PLOT PLAN / SPECIAL USE DRAWING

site plan drawing_v3-redline.pdf Markup Summary

PLOT PLAN / SPECIAL USE DRAWING

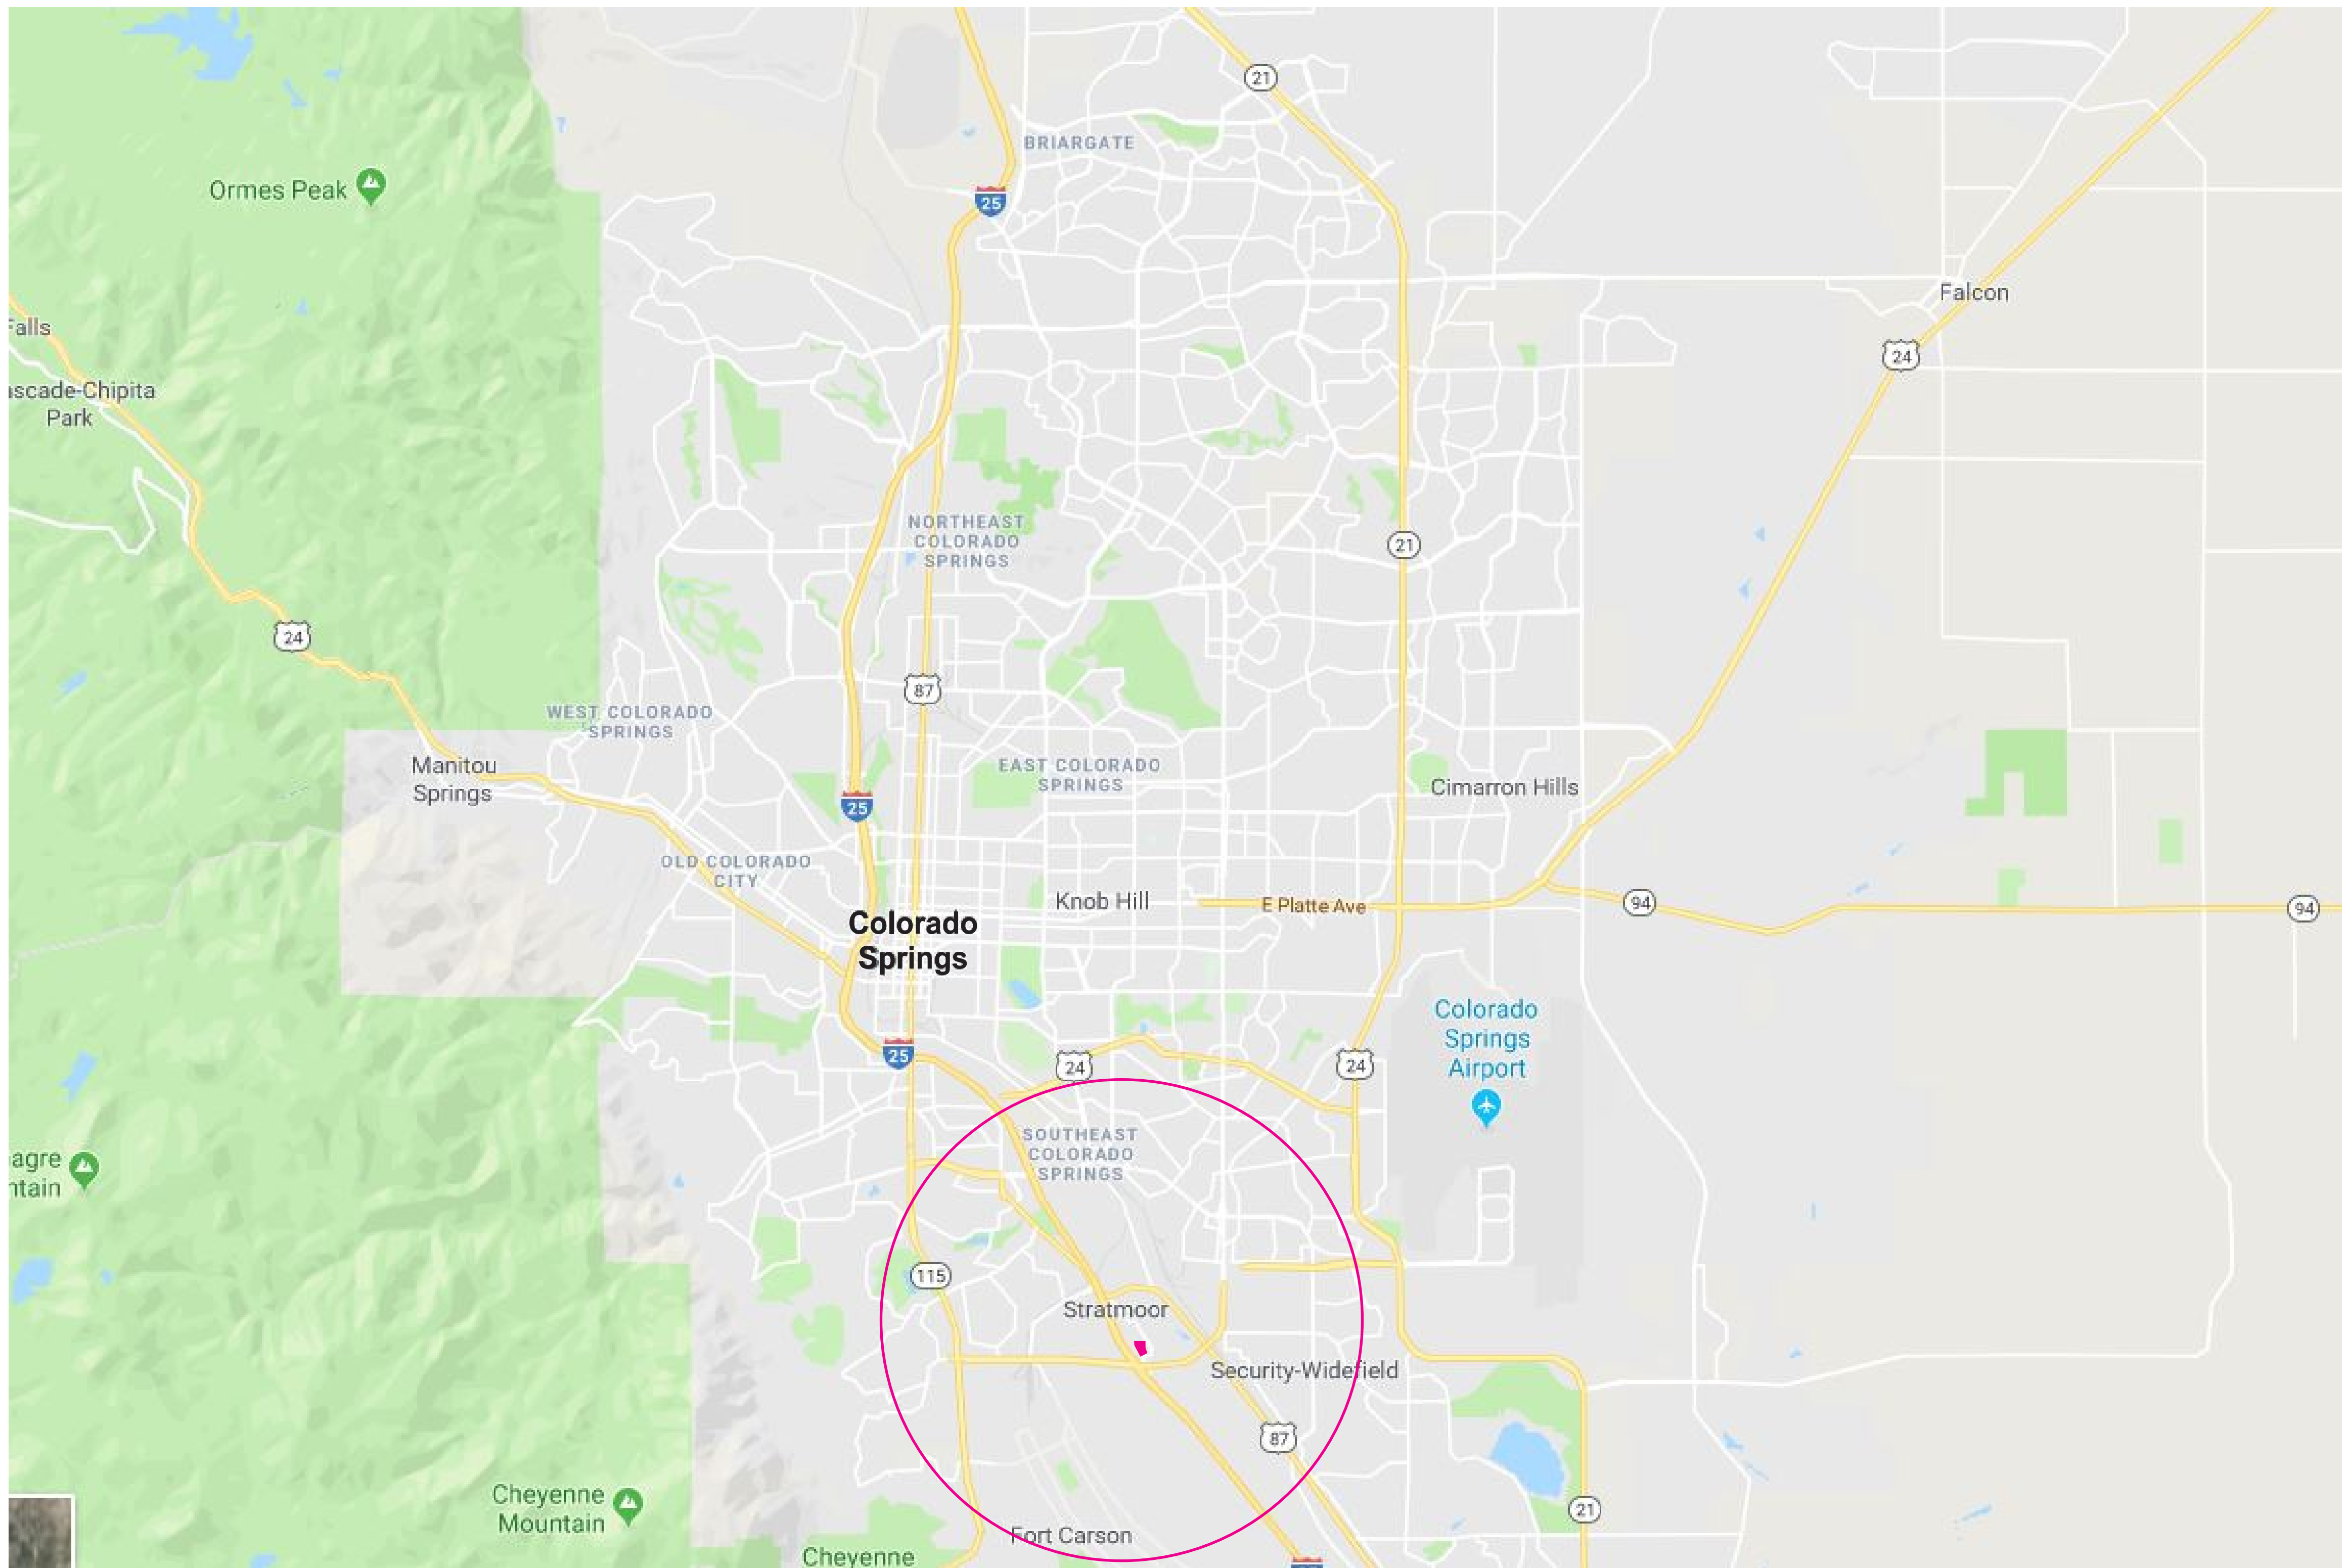
Show setback

Show that only 50%
of the front yard
setback will have
storage in it.
